Your Ref: OWPC26462
Our Ref: BE/89/19/PL 31-07-2019
Please ask for:
Maria Tomalova

The change of use of land for the storage of building materials, equipment & plant & for the parking for fixed body vehicles together with part boundary screen fence with a secure gated access point to the site.

Babsham Business Centre Babsham Lane Bersted

Thank you for your internet representation made on 20th April 2020 which has been recorded as **'an objection'** with the comments as follows:

PROPOSED SITE PLAN - 1:200

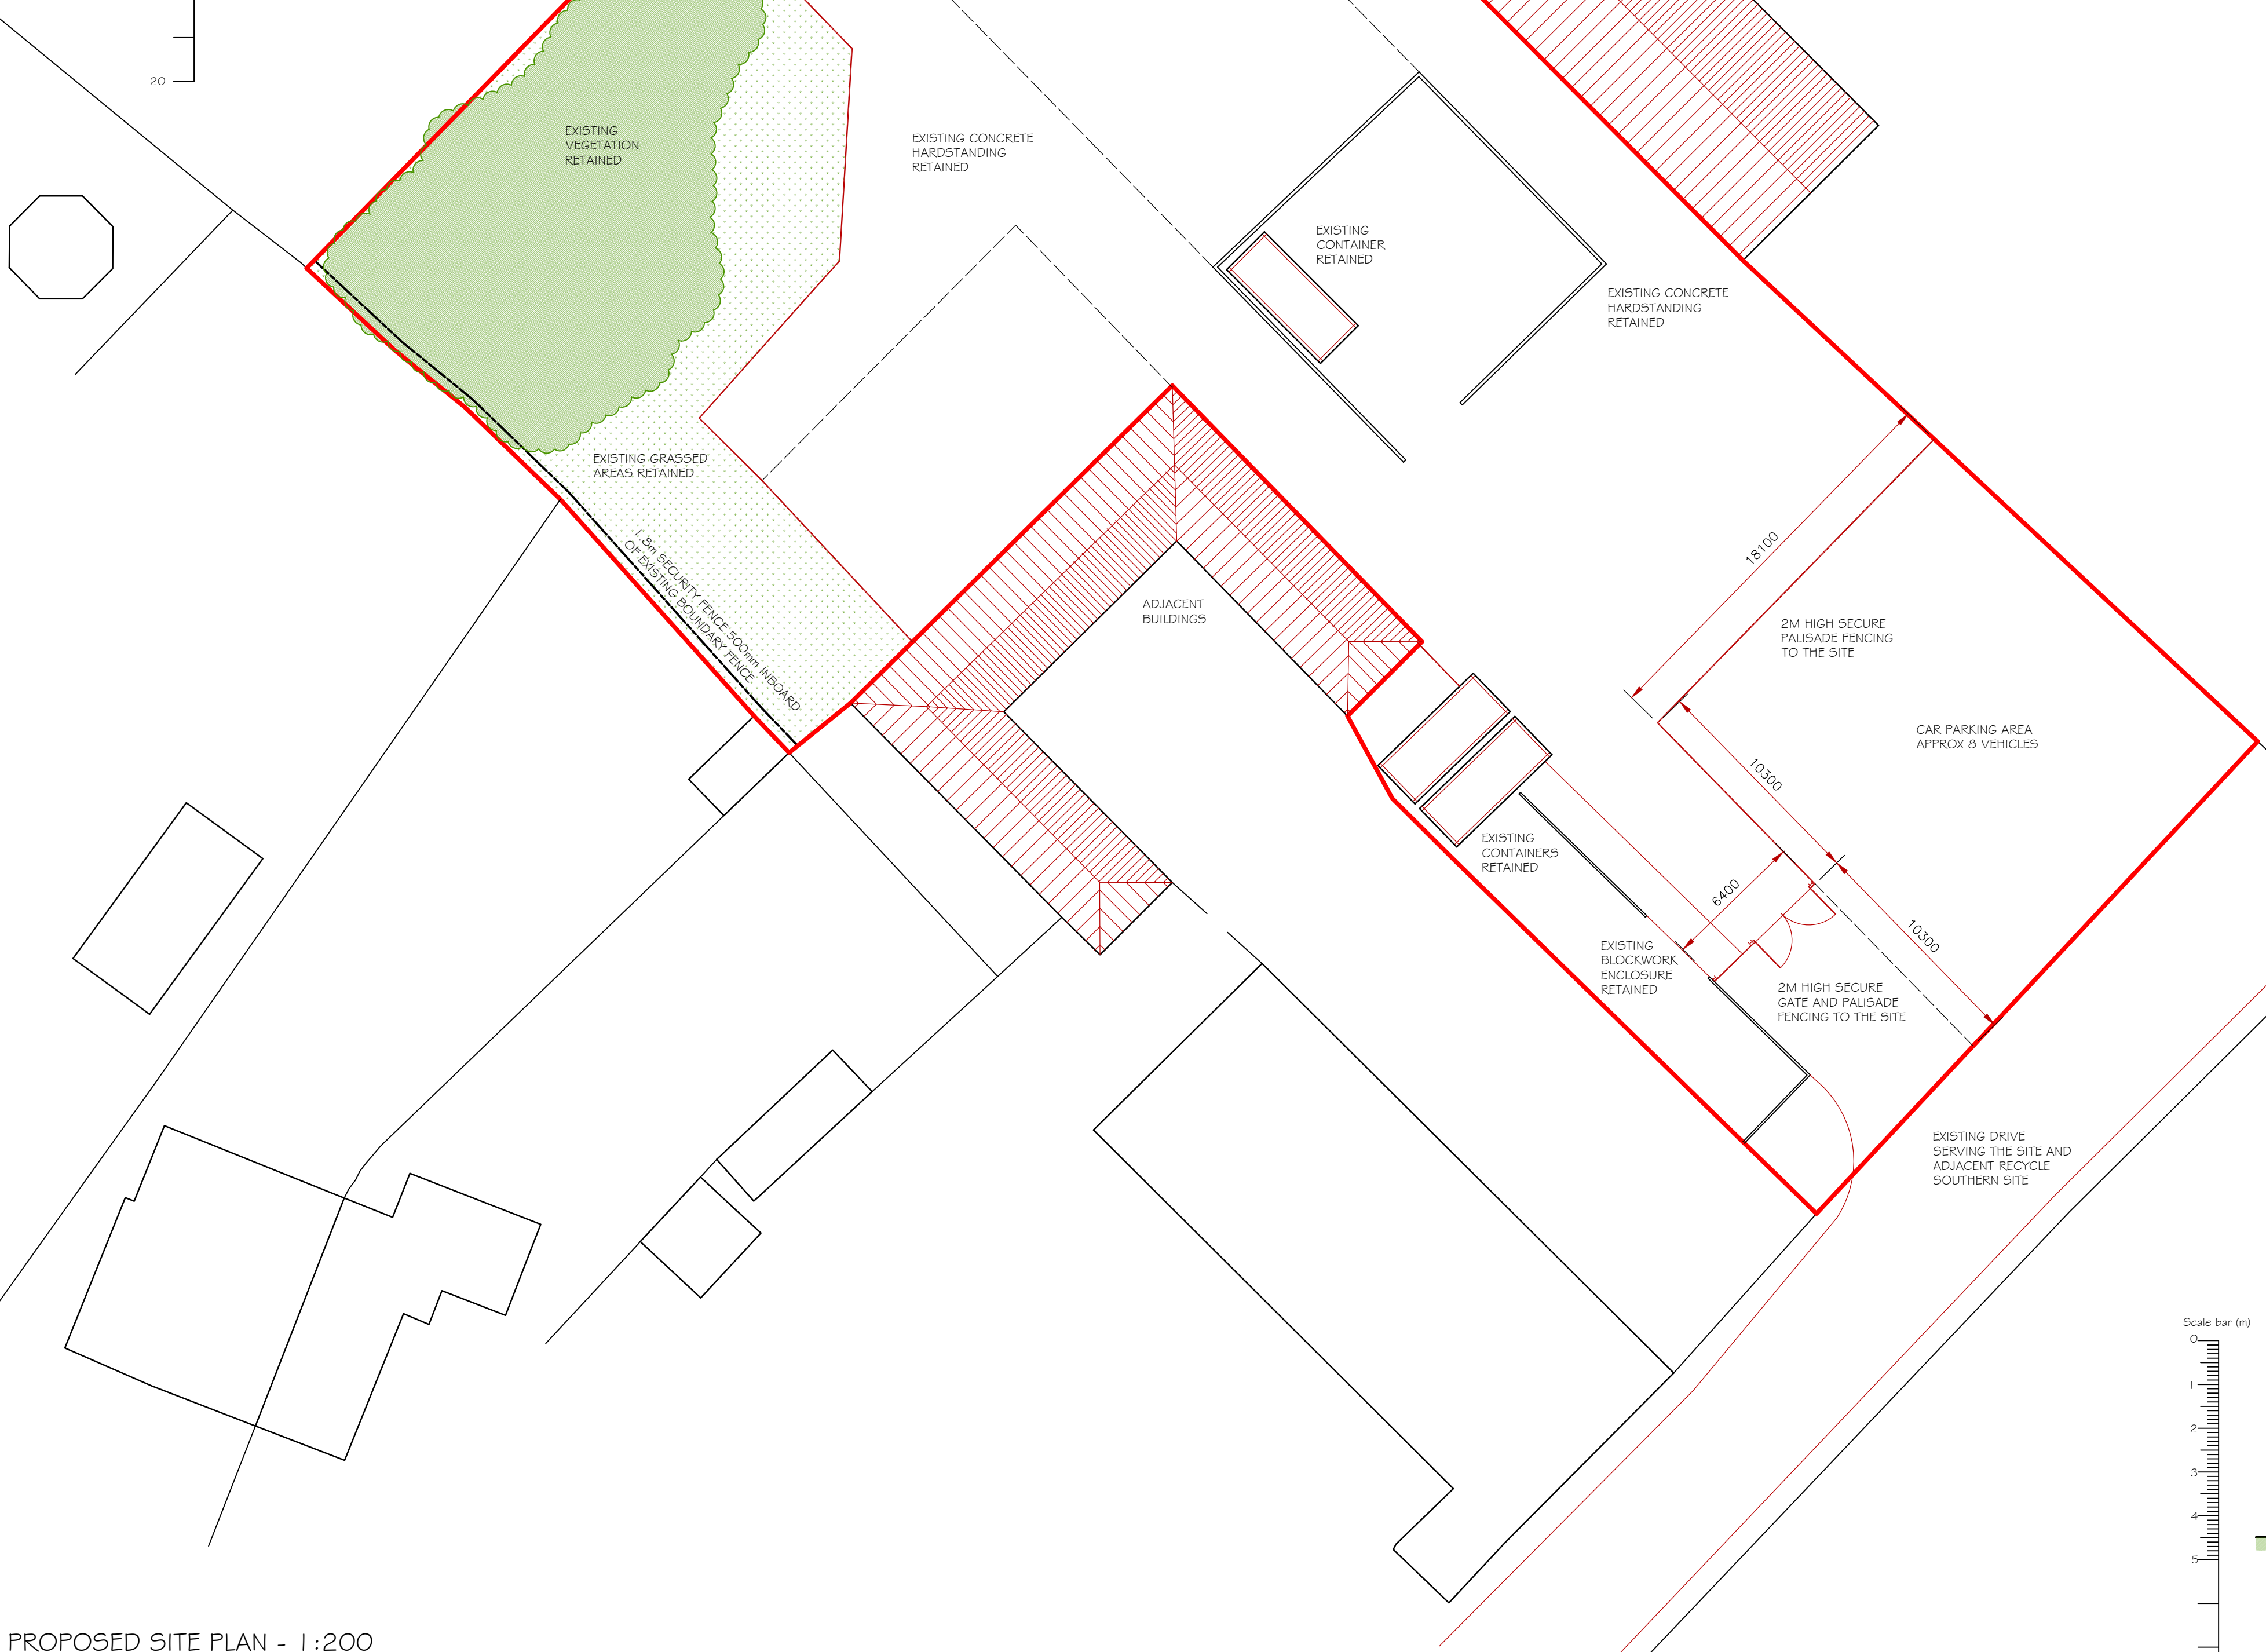
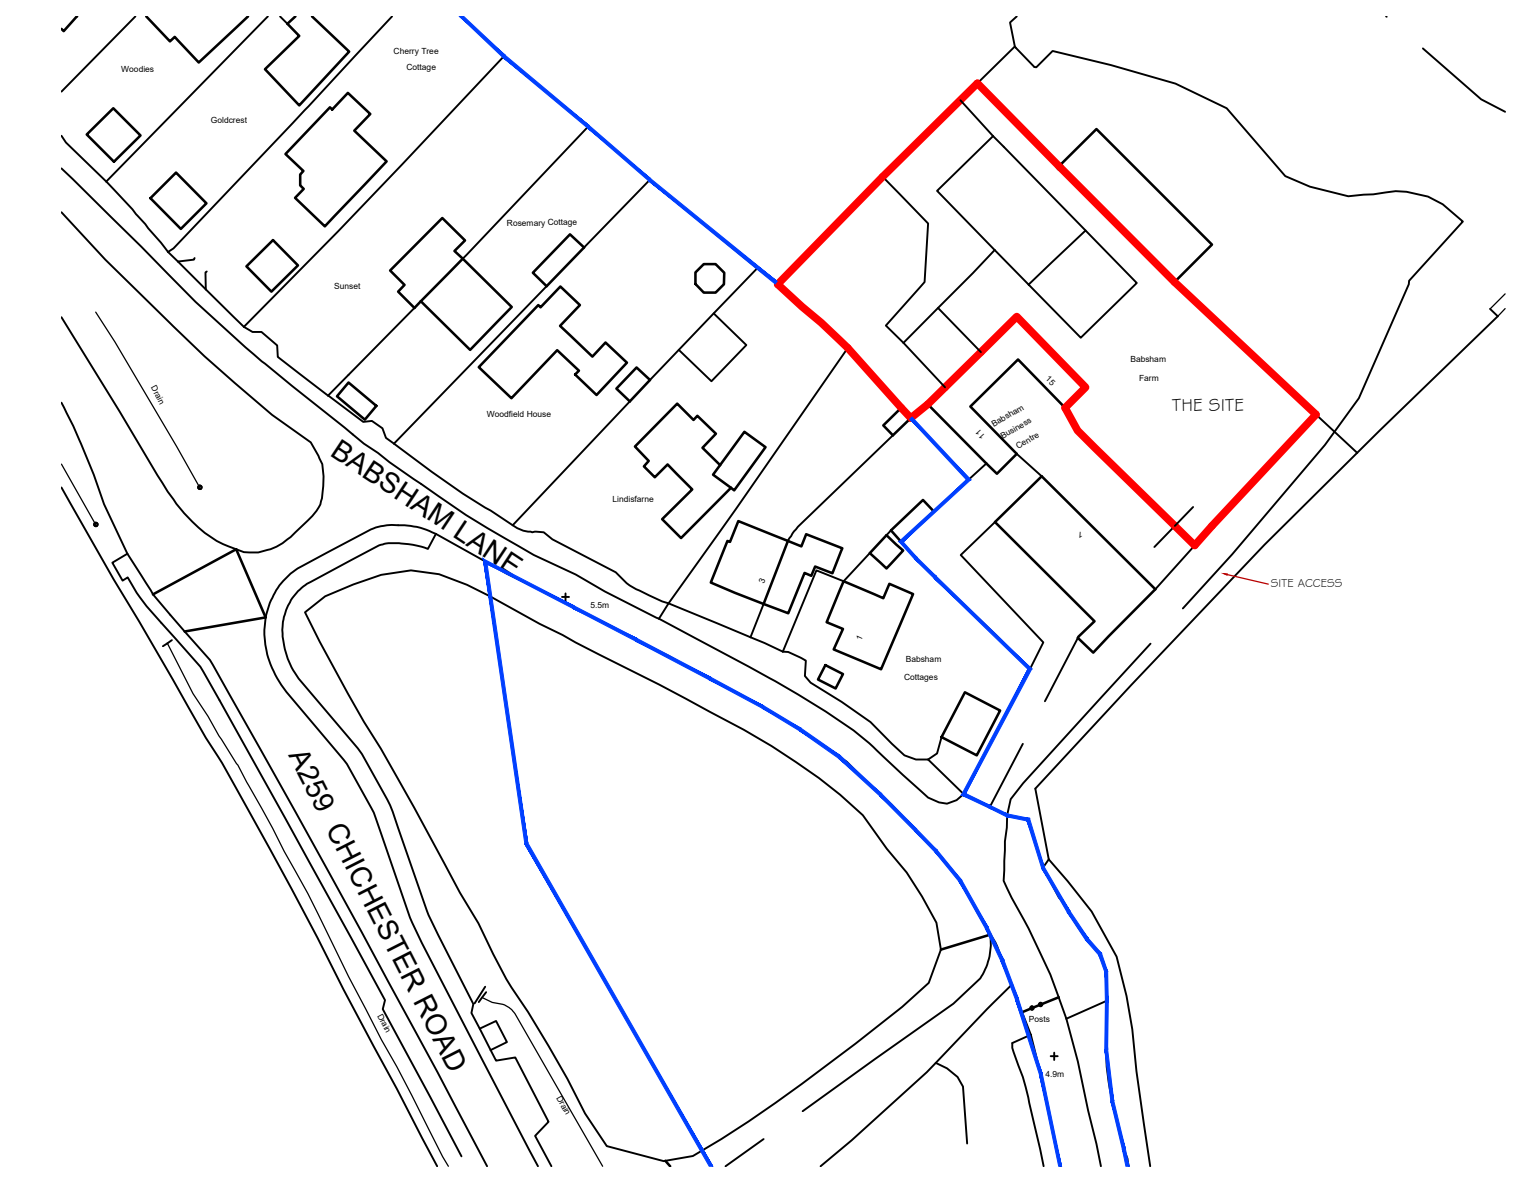
With reference to the revised plan, we observe that there has been no alteration to the proposed 2.4m fencing to be erected adjacent to, and parallel with, the existing 1.7m brick wall that forms the boundary to the rear of this residential property.

We are advised that a survey of the area marked 'existing vegetation retained' will demonstrate that it is not possible to erect the proposed fencing without severely disturbing this vegetation, and damaging the trees thereon. Furthermore, the proposed installation of the fencing risks undermining the existing boundary wall, and we would be seeking assurance in writing that the applicant takes full responsibility for any damage incurred.

We would respectfully draw attention to the original application which states that there would be 'no negative impact upon the natural environment' and that it would 'not detract from the quality of the area nor have any increased diverse impact on adjacent residential uses'. It follows, therefore, that any permission granted for this planning application needs to include the condition that the area of existing vegetation will, in fact, be retained as it appears on the plan in its entirety.
